# CITY OF PORTLAND BUILDING PERMIT

Located At 15 ALLISON AVE

Job ID: 2012-11-5356-SF

**From:** Jonathan Rioux <JRIOUX@portlandmaine.gov>  
**To:** dkchrist59@yahoo.com  
**Sent:** Friday, November 30, 2012 1:19 PM  
**Subject:** 15 Allison Ave.

Project Name:	Contractor:	Drawn By:
Hights	Construction System of New England	Crystal Bourassa Date: October 1, 2012 Revised: November 2, 2012

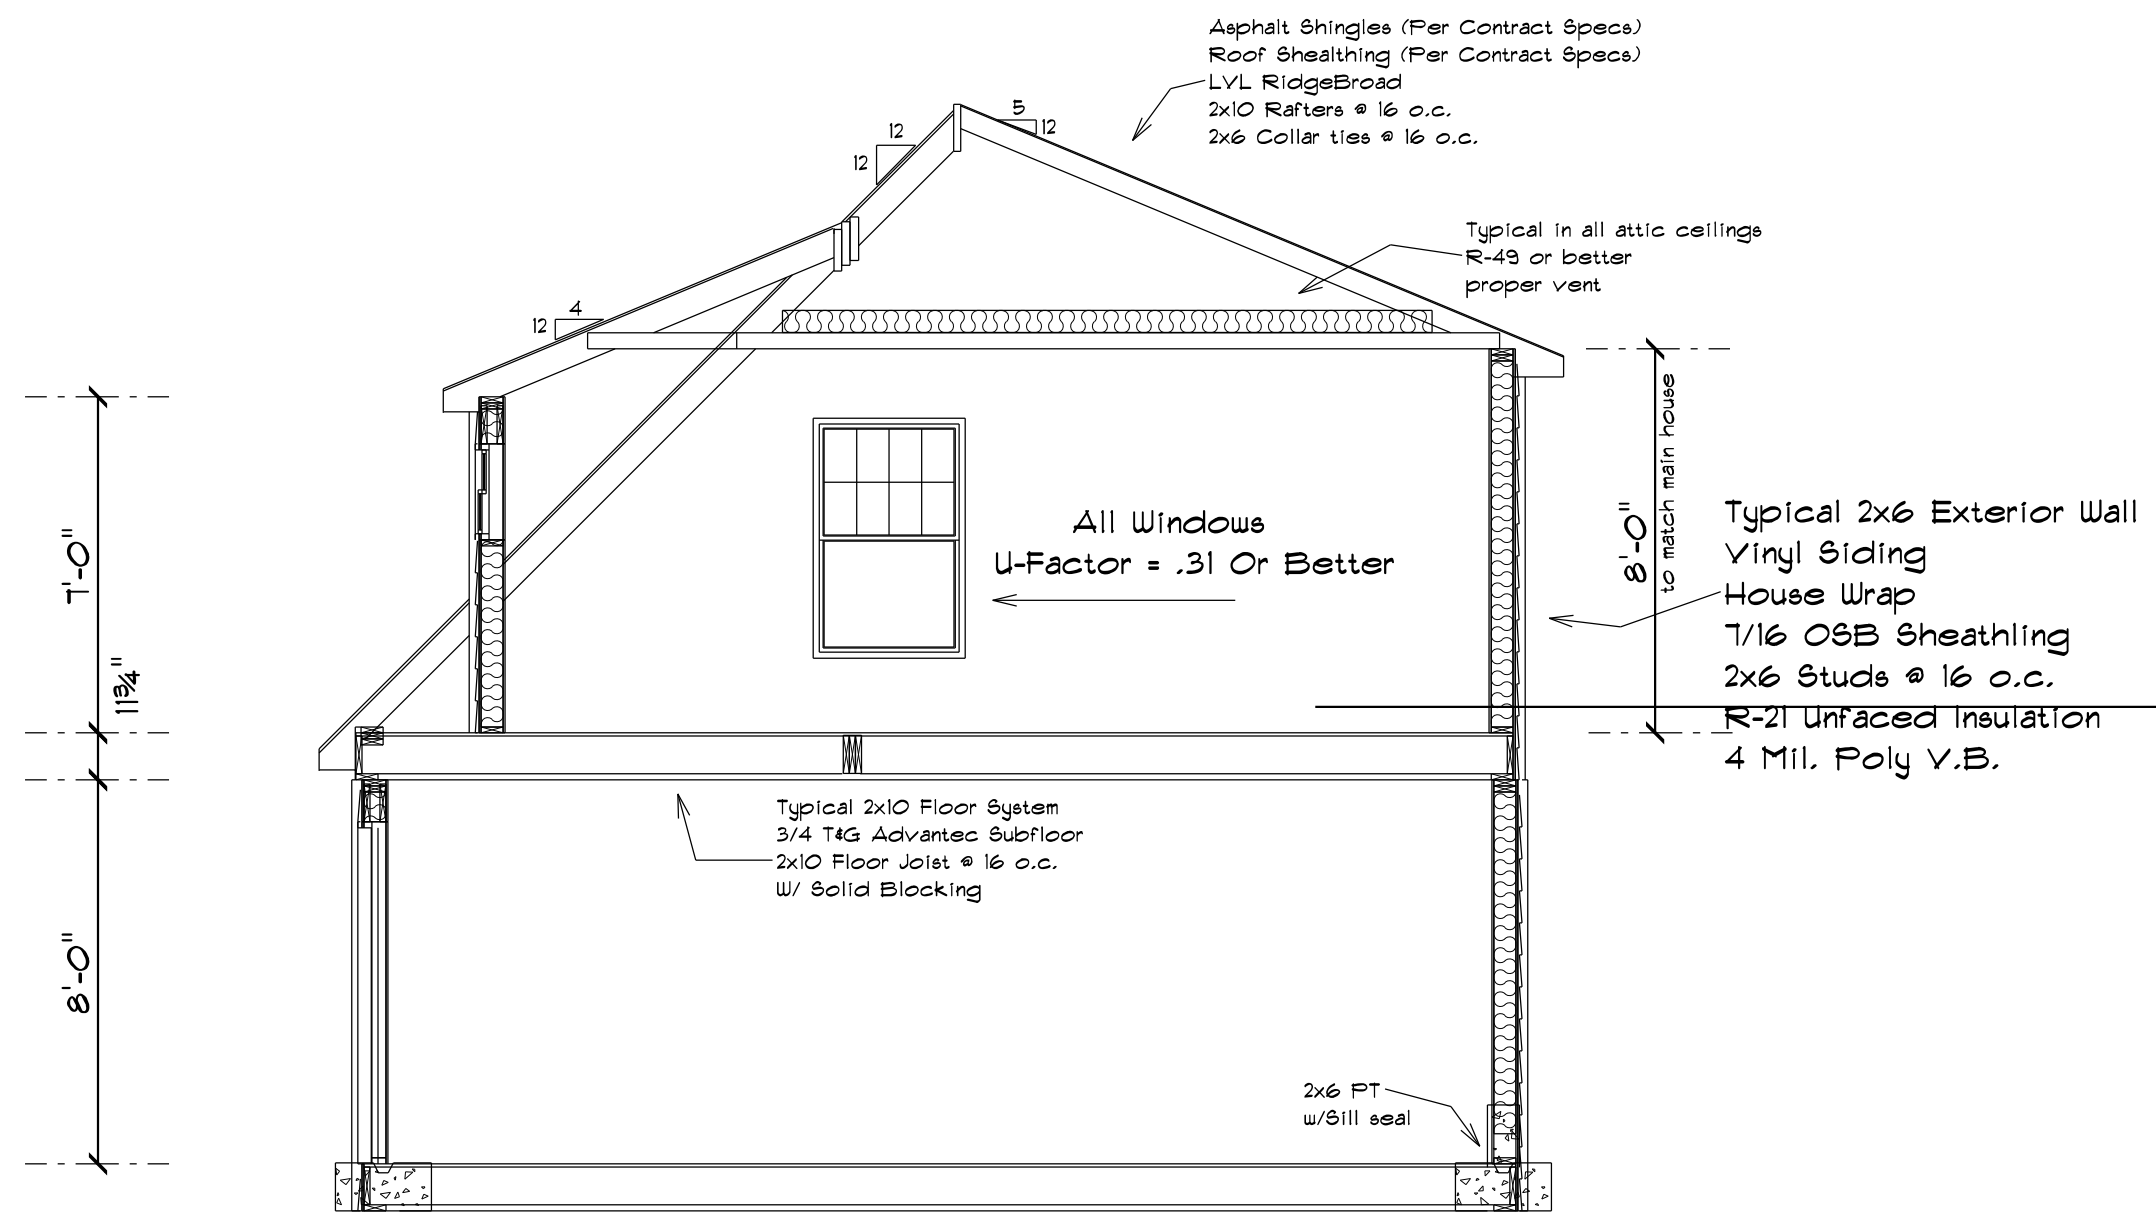
The information below was missing on the building permit application. The floor framing plans/ cross sections need to indicate the (3) 2 x 12 girder spans/ spacing between each lally column; the roof framing plan must show how the dormer meets the 2 by 10 inch rafters, with finished headroom. All bulleted items require a response for permit issuance.

- Footing Dimensions/Depth 20" x 10"
- (Table R403.1 & R403.1(1), (Section R403.1 & R403.1.4.1)
- Foundation Drainage, Fabric, Damp proofing Indicated in the cross section but not spelled out. Also clearly shown in the drainage design
- (Section R405 & R406)
- Ventilation/Access (Section R408.1 & R408.3) shown in cross section at eaves with propa vent and ridge vent at peak
- Crawls Space ONLY
- Anchor Bolts/Straps, spacing (Section R403.1.6) Bolts at 6' o.c.
- Girder & Header Spans between lally columns? (Table R 502.5(2)) on foundation plans
- Built-Up Wood Center Girder shown in cross section

- **Dimensions and Spacing** dimensions are on floor plan. spacing is shown in the cross section
- (Table R502.3.1(1) & Table R502.3.1(2) )

- Roof Rafter; Framing & Connections (Section R802.3 & R802.3.1)
  - Rafter tie connection to top plate? not shown but I use H2.5 hurricane clips
- Fastener Schedule (Table R602.3(1) & (2) ) not shown

Thanks for your feed back. I am wondering if you have a complete set of plans where as most of what you have listed is on the plans. The spacing for the columns is in the foundation plans. The size of the girder is in the cross section. I have attached the plans in case you are missing a page. I started to go through your list and am realizing that I should just schedule a time to meet with you to go through this since I to have questions as to what you are asking for. I will bring in anything that is not listed on the plans with me as you have noted. I will call later to try and set up a time to meet sometime this week.
